From: [Julia Errington](#)
To: [Anson Tong](#)
Subject: Advice on Modification – Harbourside Podium and Tower MOD 7 – Substation Plant (SSD-49295711-Mod-7)
Date: Wednesday, 22 October 2025 10:35:00 AM

2. Substation 4

General Arrangement - L00 Ground Plan

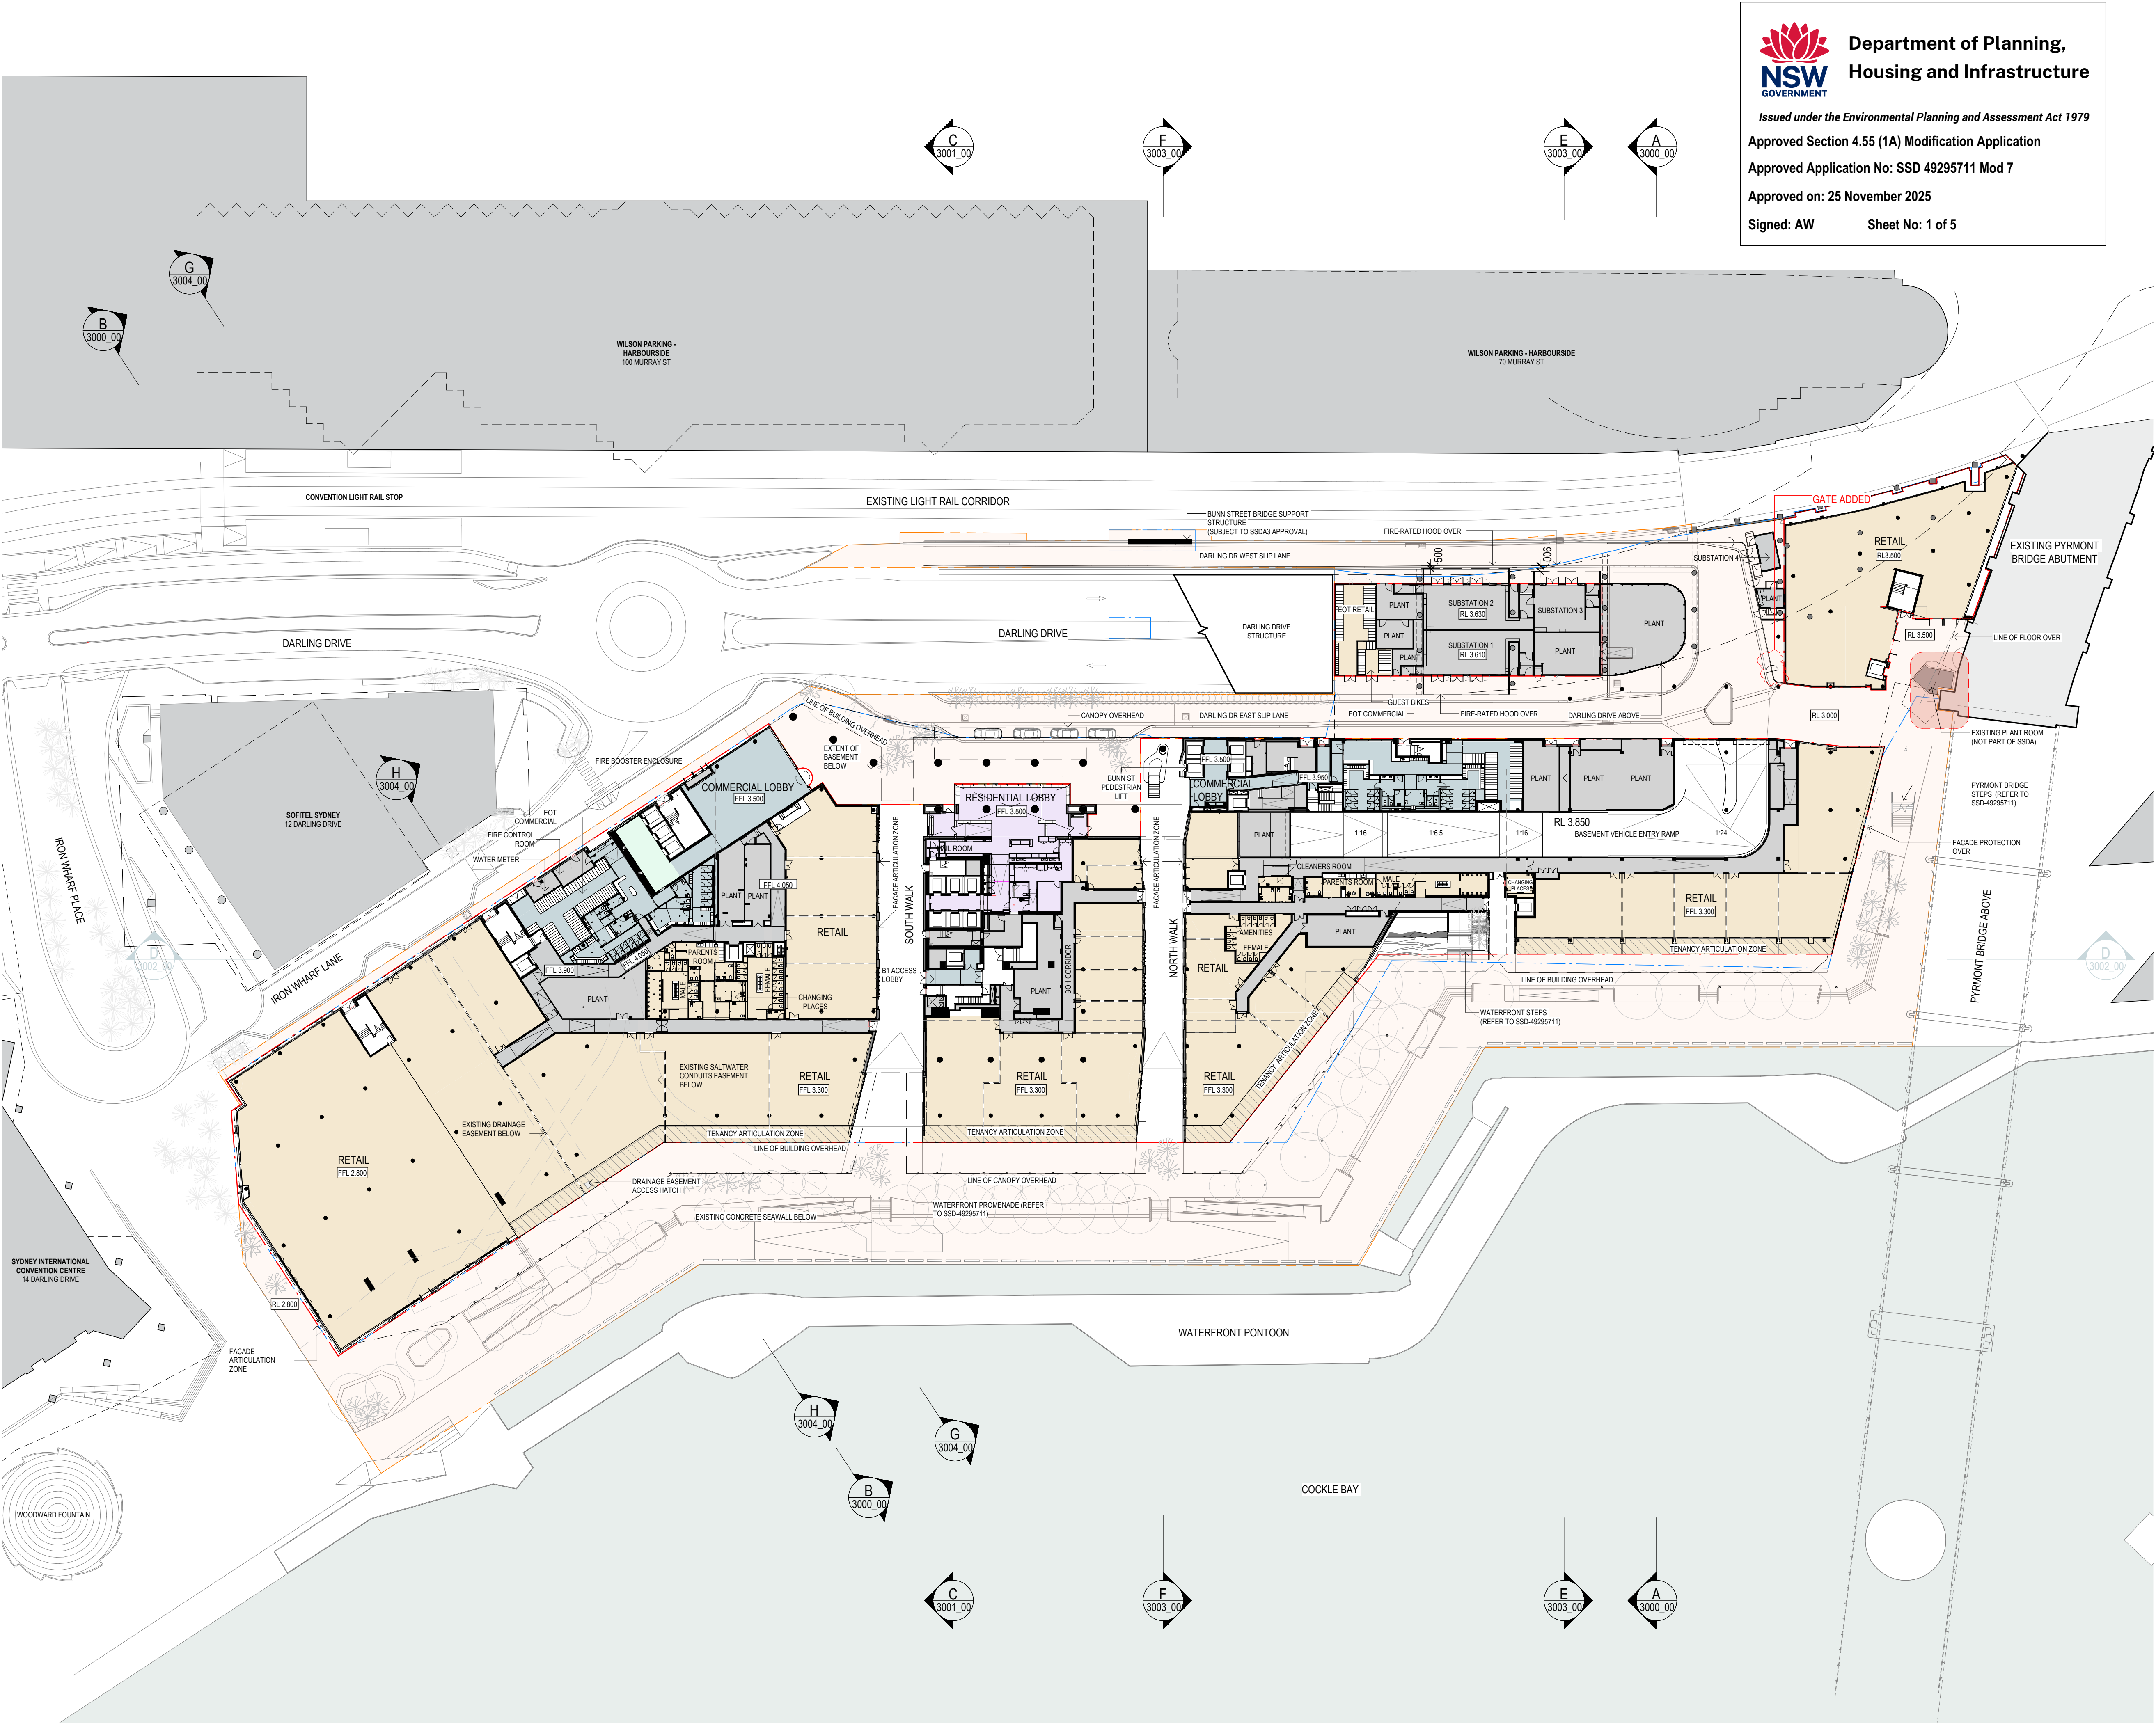
It is understood that the proposed fire hoods to substations 1 -3 are required to meet Ausgrid requirements for fire protection. It is unclear if the location of the proposed substation hoods is able to be accessed by pedestrians. Where accessible, the proposed full width hoods would obstruct pedestrian movements and create a safety issue whereby persons walking along the footpath would have to step onto the roadway to navigate around the hoods.

It is also not clear how access to the substations will occur for servicing. Vehicles parked immediately adjacent would block all vehicle movements.

It is recommended that the hoods be set back from the roadway where possible for pedestrian safety and to prevent impacts from moving vehicles, particularly wing mirrors and other obstructions.

Swing doors

The proposed double swing doors to Substation 4 encroach into the roadway. It is suggested that doors opening into the roadway be limited/ consolidated where possible. It is recommended a management strategy is developed for when doors are in operation.
